Office of
Environment
& Heritage

RE: OEH SUBMISSION FOR THE WALLARAH 2 COAL PROJECT (SSD_4974)

OEH review of the Wallarah 2 Coal Project (SSD_4974) in relation to threatened biodiversity, heritage, flooding and surface water management and environmental impacts resulting from subsidence.

Figure 2: Project Layout

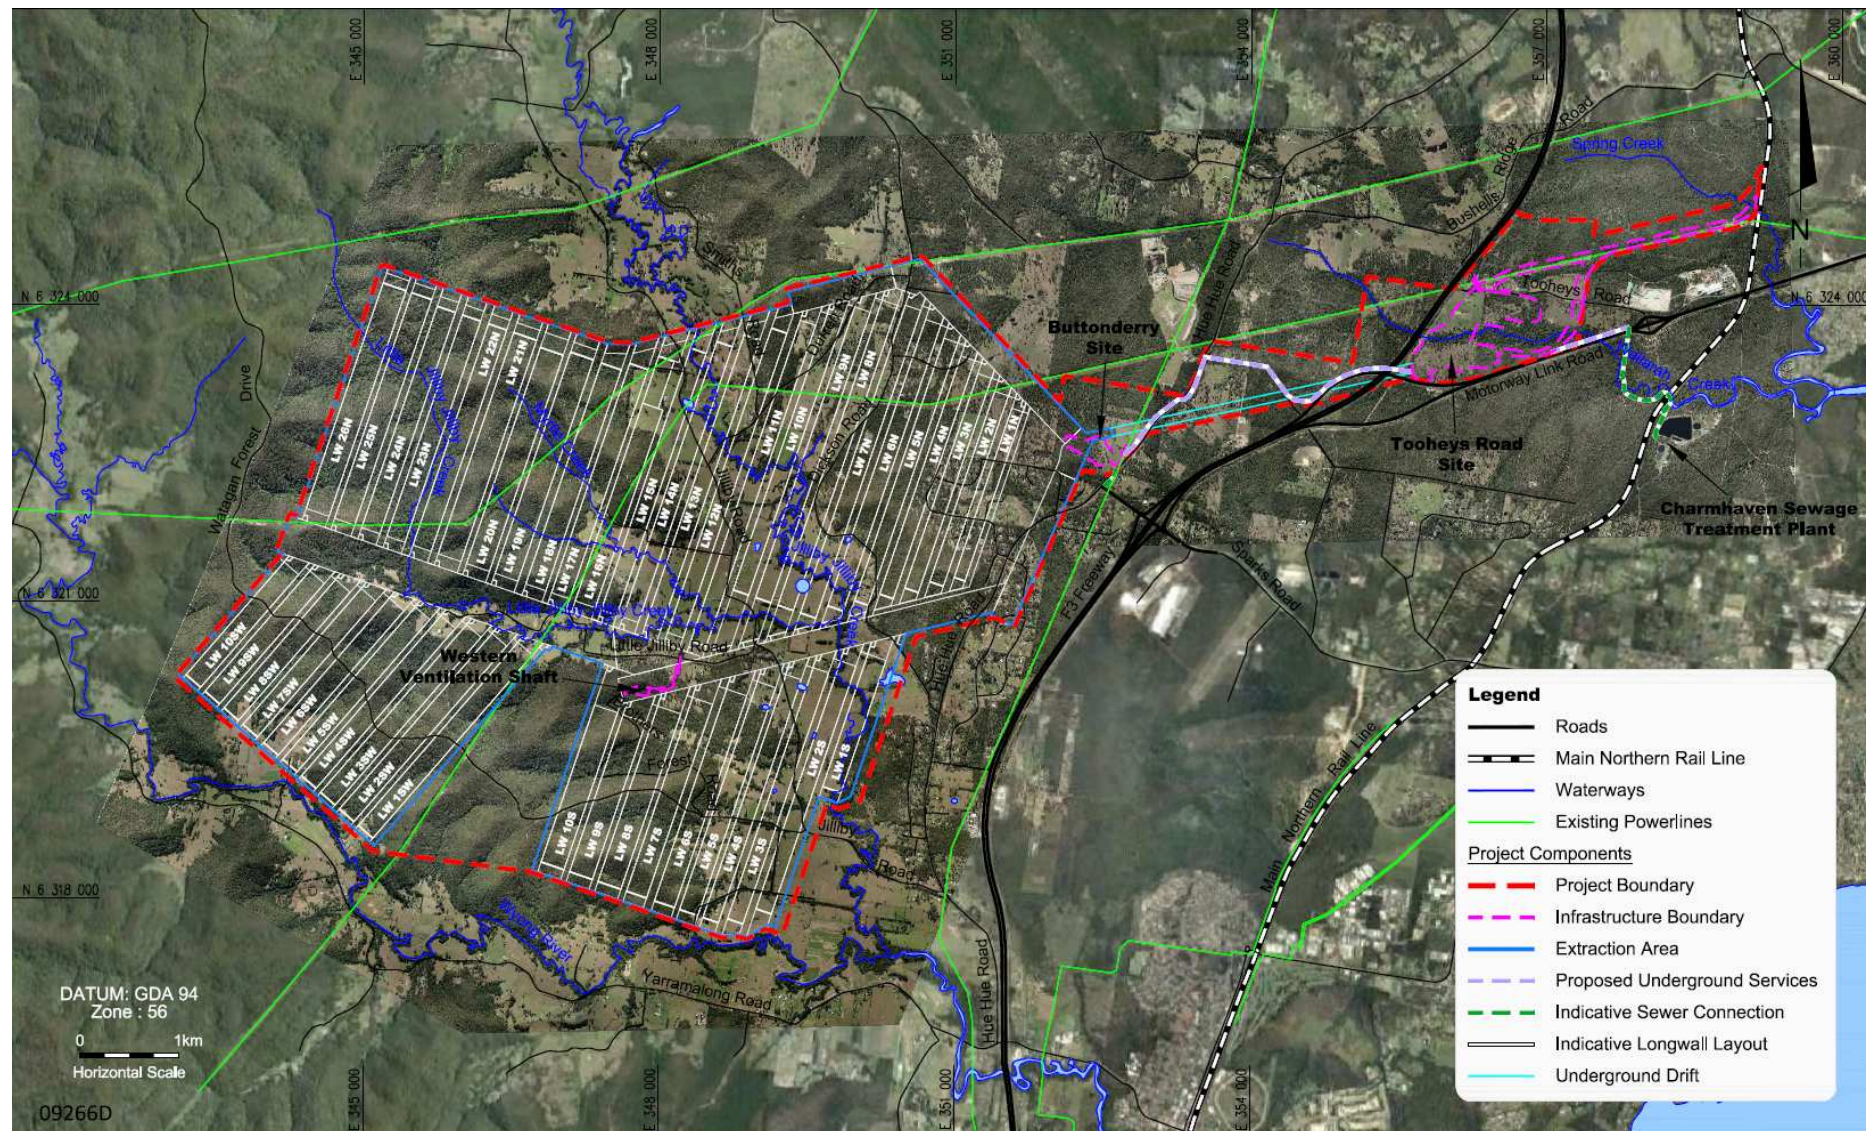
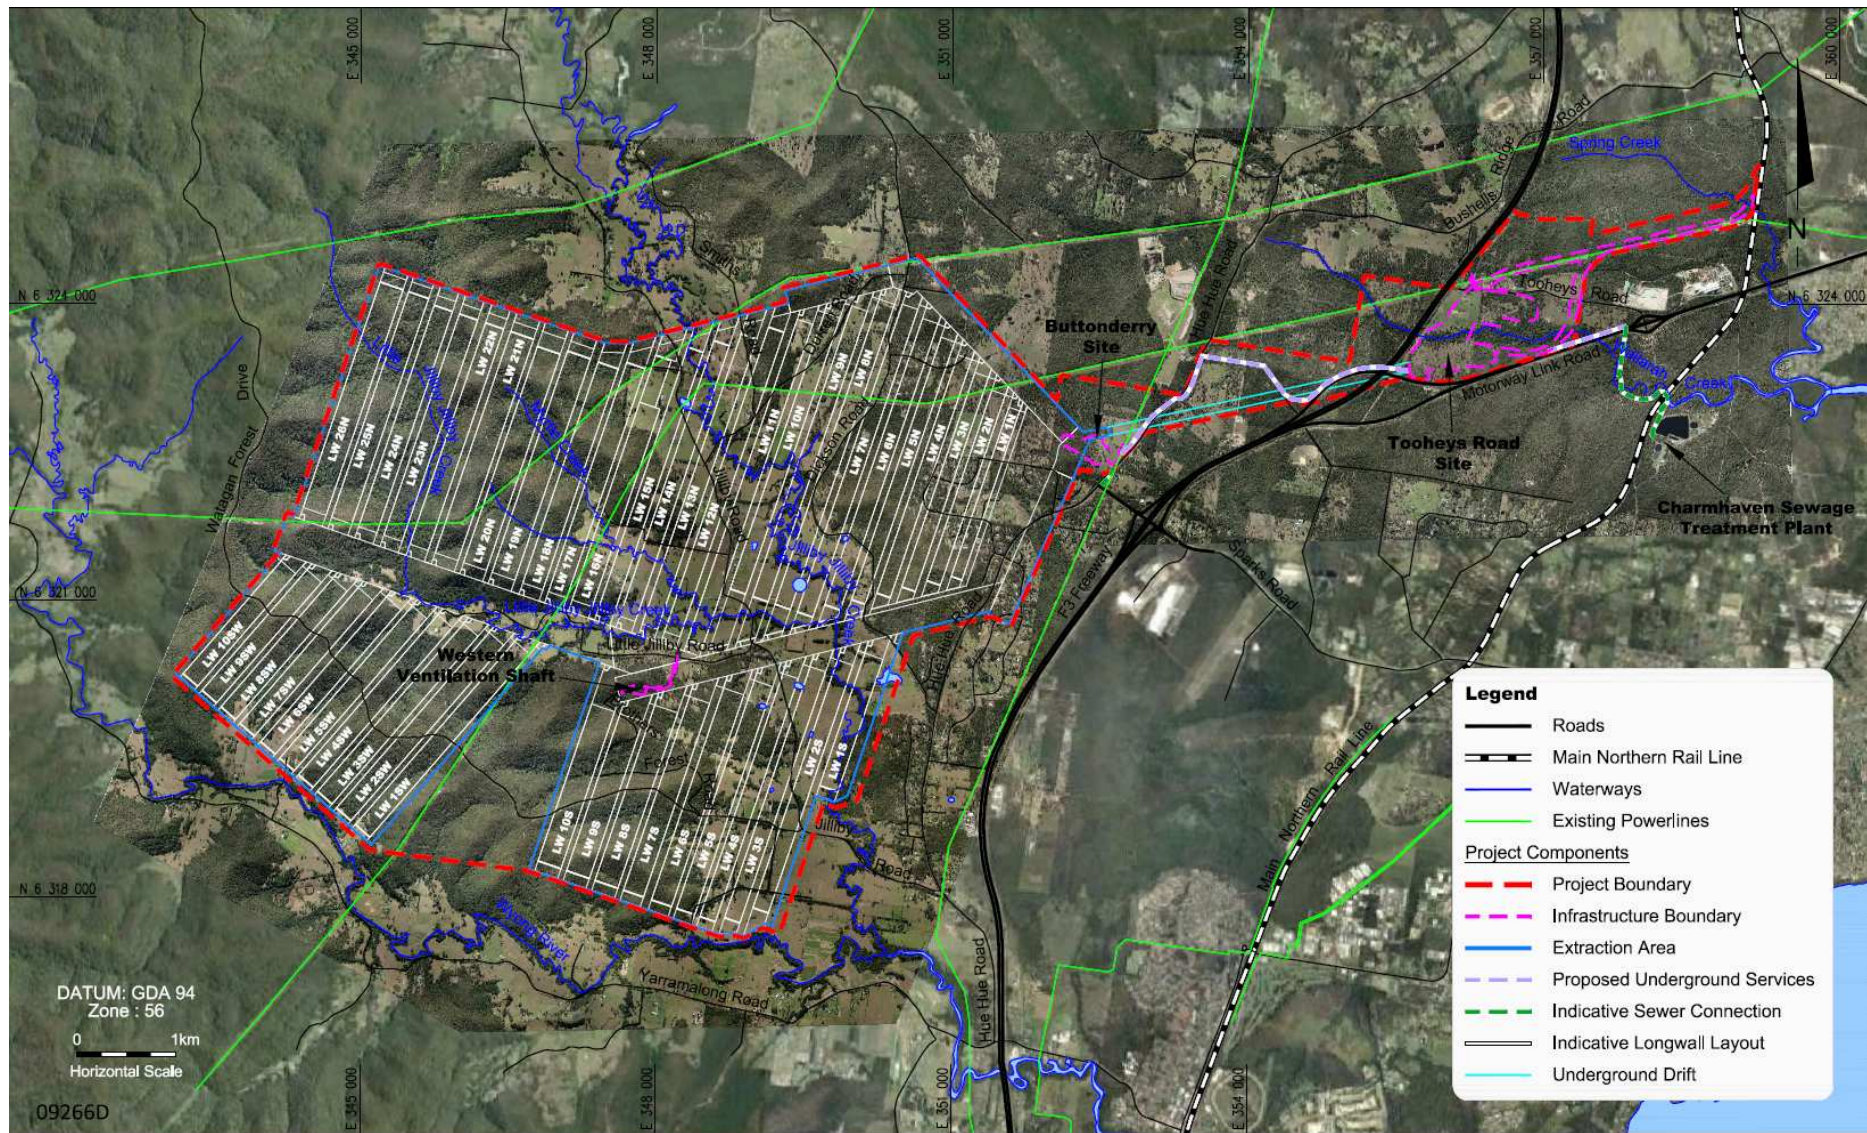
1. In order to prevent permanent damage to sensitive groundwater aquifers, surface water systems threatened ecological communities and the habitat of threatened species, the proponent redesign the longwall layout so as to preventing longwalls being extracted directly under Little Jilliby Creek, Myrtle Creek, Armstrong Creek and Jilliby Creek or within their angle of draw.

OEH does not believe this can be achieved without redesigning the longwall layout and preventing longwalls being extracted directly under Little Jilliby Jilliby Creek or within its angle of draw.
